**J. SMITH STRUCTURAL ENGINEERING, PLLC**  
N.C. CERTIFICATE NUMBER P-2212

June 29, 2023

**RE:** 90 Auger Hole Road  
"The Harrison"  
As-built framing review

**S-3
 CEILING FRAMING
 PLAN**

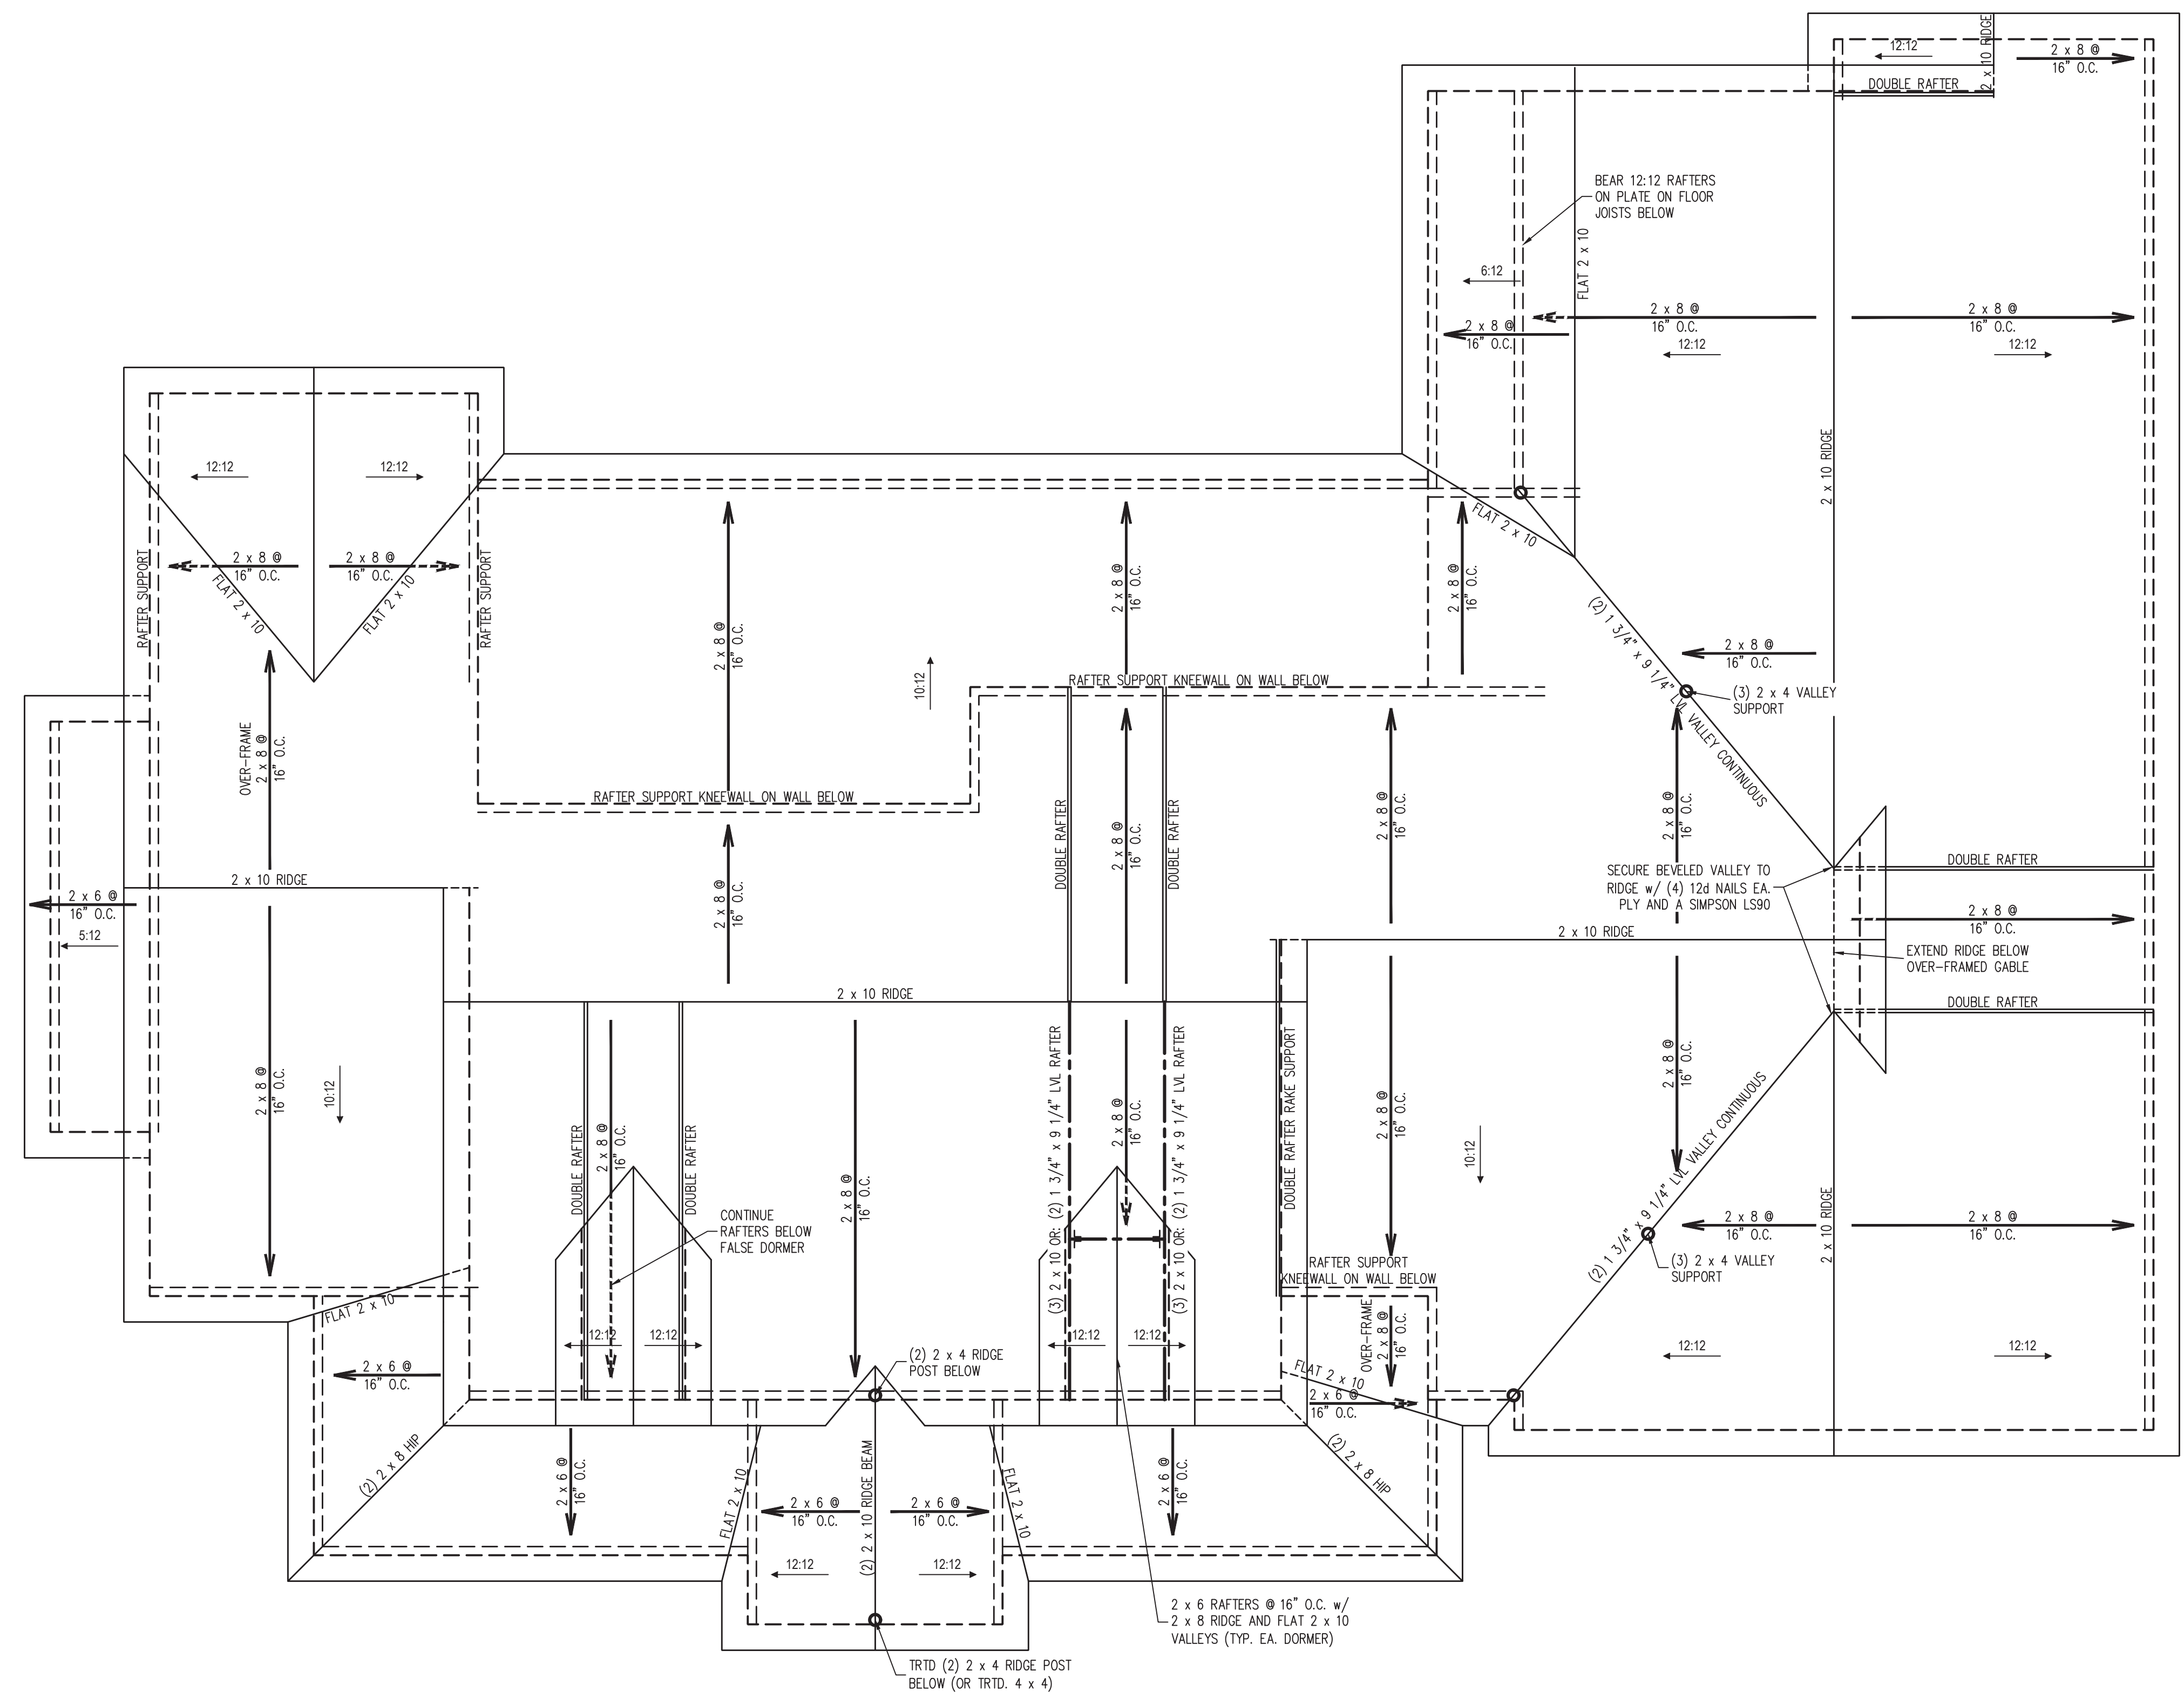
- At the front porch, a single 2 x 10 ridge was installed with 2 x 6 collar ties @ 16" o.c. in lieu of a (2) ply 2 x 10 ridge beam with and open vault below. This framing configuration is adequate to support all applied loads.
- At the (2) 1 3/4" x 9 1/4" LVL valley over the master bedroom, the as-built valley was framed with a splice located approximately three feet from the end bearing point. This framing configuration is adequate to support all applied loads and no reinforcement is required.
- Over the master bedroom, the 12:12 pitch rafters bear on a 2 x 4 plate on top of the 11 7/8" I-joist floor system as noted on the engineered drawings. This framing configuration is adequate to support all applied loads.
